March 12, 2019

SH 21A  
El Paso County

RE: Trails at Aspen Ridge (Springs East at Waterview) - PUDSP-191 - **Filing 2,3 and 4**

## PUD Site Plan

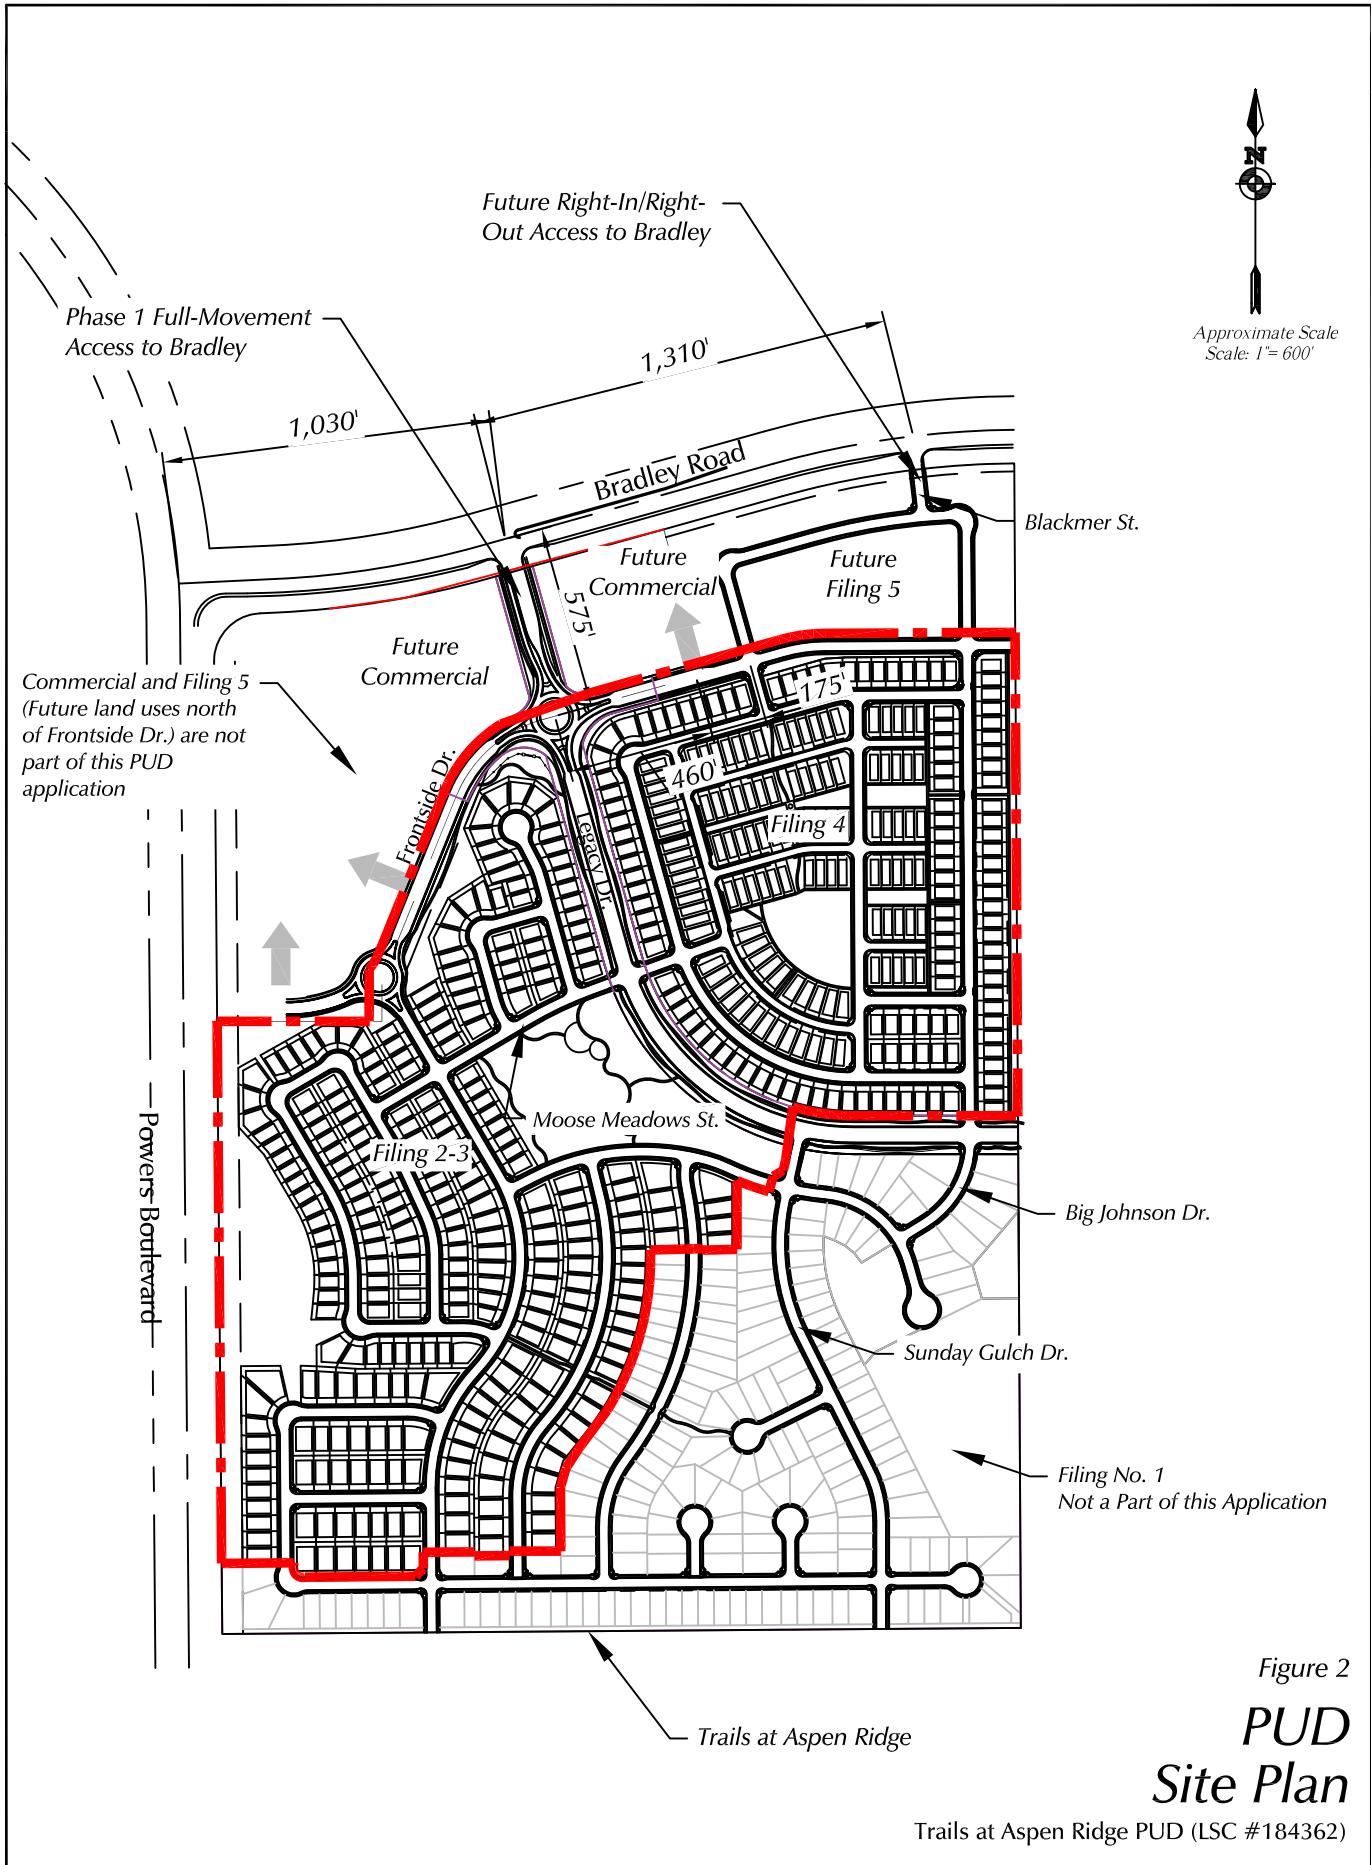
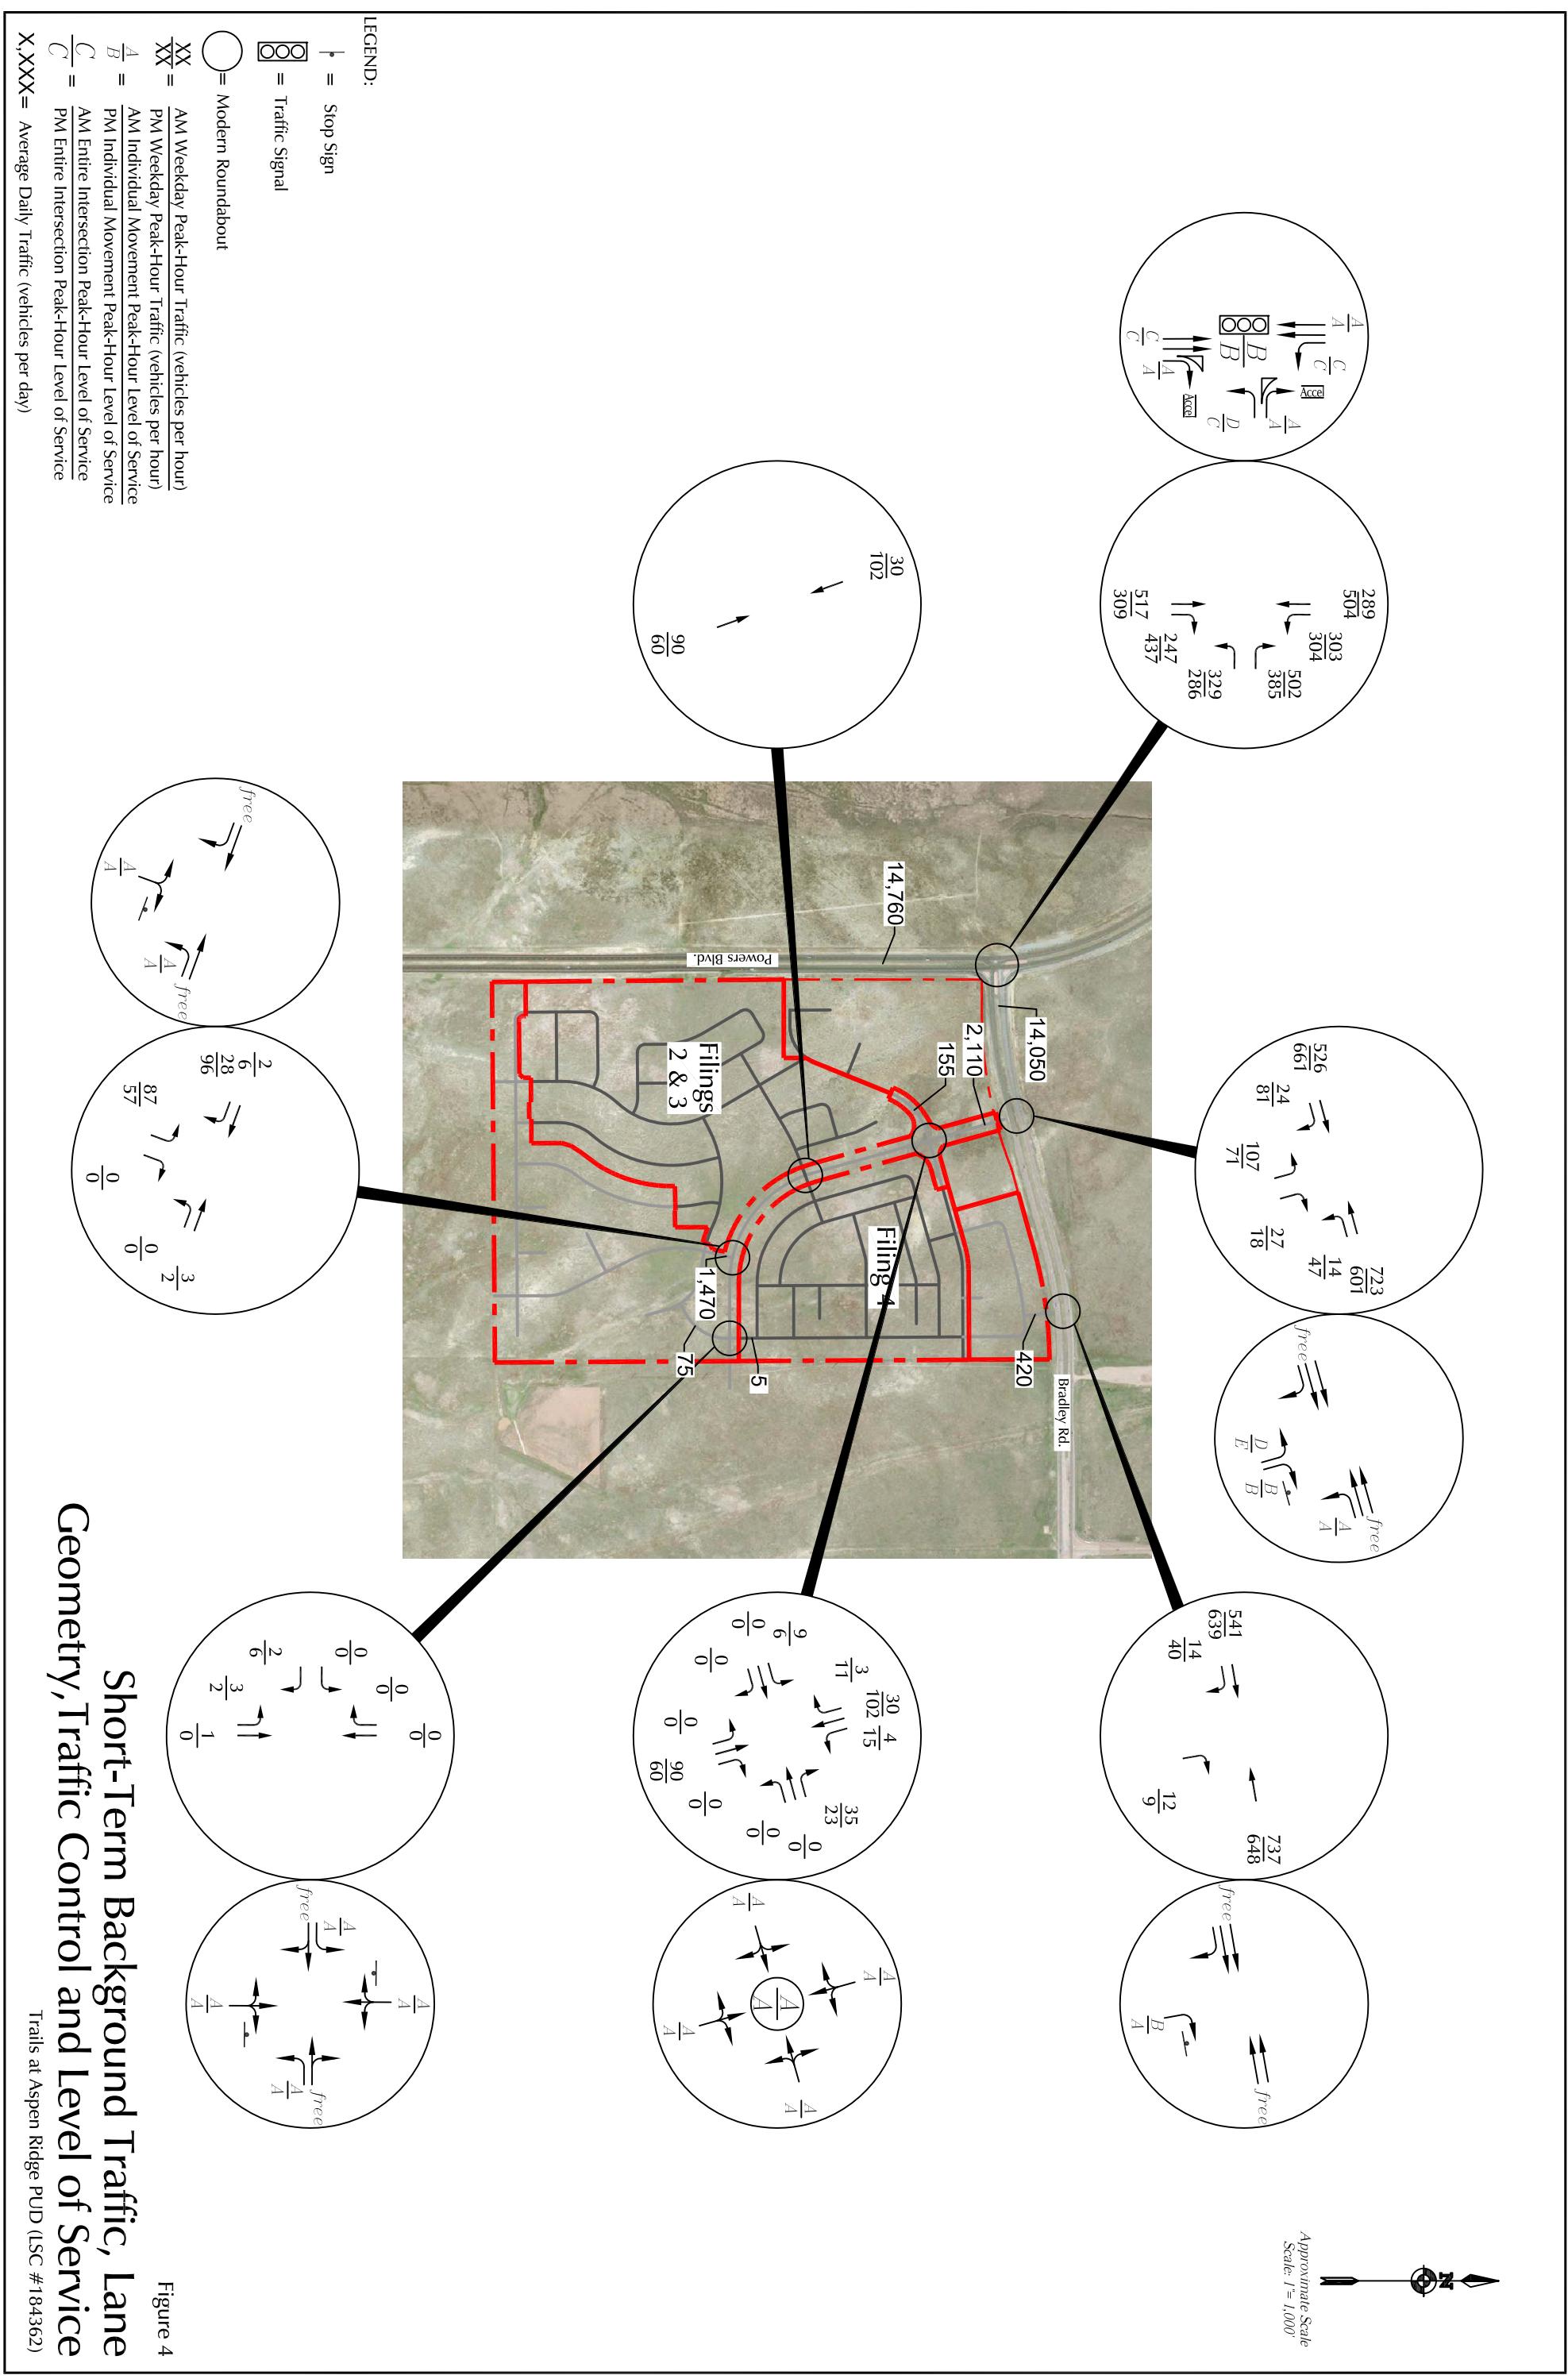
- Page 6 states that the southbound left turn lane on Powers Blvd can be restriped as dual left turn lanes, however there is no road surface for such restripe; a 150-ft long raised median exists at that location.
- Bradley Road has been restriped for dual westbound left turn lanes when the signal was installed; Table 4 should be updated.
- The 2040 assumption of a six-lane Powers Blvd at Bradley overlooks the cost comparison of an interchange versus widening three miles of highway particularly with ADTs only at 40,000. The study should include an interchange alternative of 2040 traffic.
- Figure 19 depicts the long-term Bradley Road lane configuration east of Powers Blvd. It is clear from the drawing that the future eastbound left turn lanes for the future north side access will conflict with the future northbound ramp intersection.
